COUNTY OF HARNETT LAND USE APPLICATION

**RE: Harnett County Land Use Application HTE# 07-5-17913 Lt#251 Crestview Est.  
THE# 07-5-17912 Lt#250 Crestview Est.**

Joe West, R.S.  
Environmental Health Specialist  
Harnett County Department of Public Health  
Environmental Health

LOT # 250 CRESTVIEW

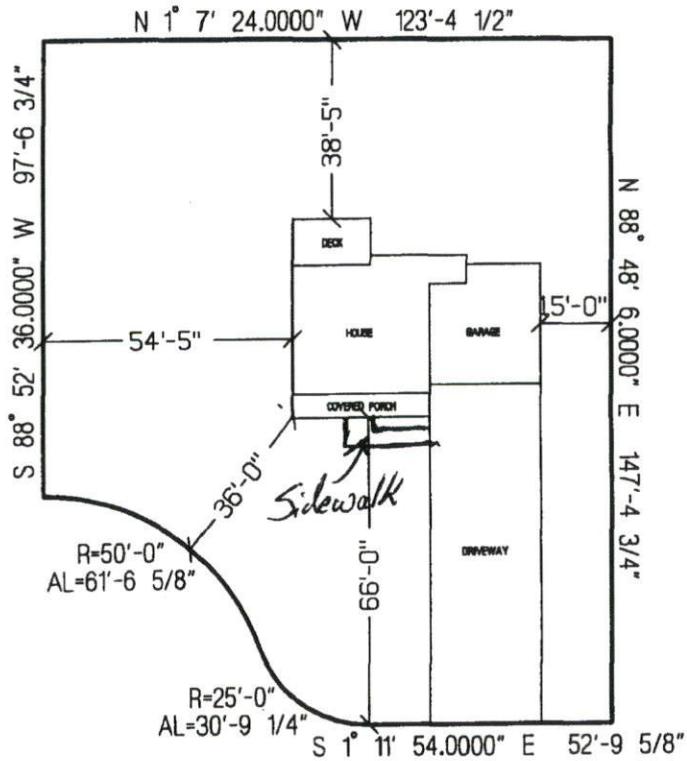
- 1. Property lines/corners not marked or labeled
- 2. House corners not marked or labeled
- 3. Directions not clear to property
- 4. Property needs brush or vegetation removed
- 5. Backhoe pits required
- 6. Other *Please move house location as shown on attached sheet and submit new plot plan with changes to Central Permitting.*
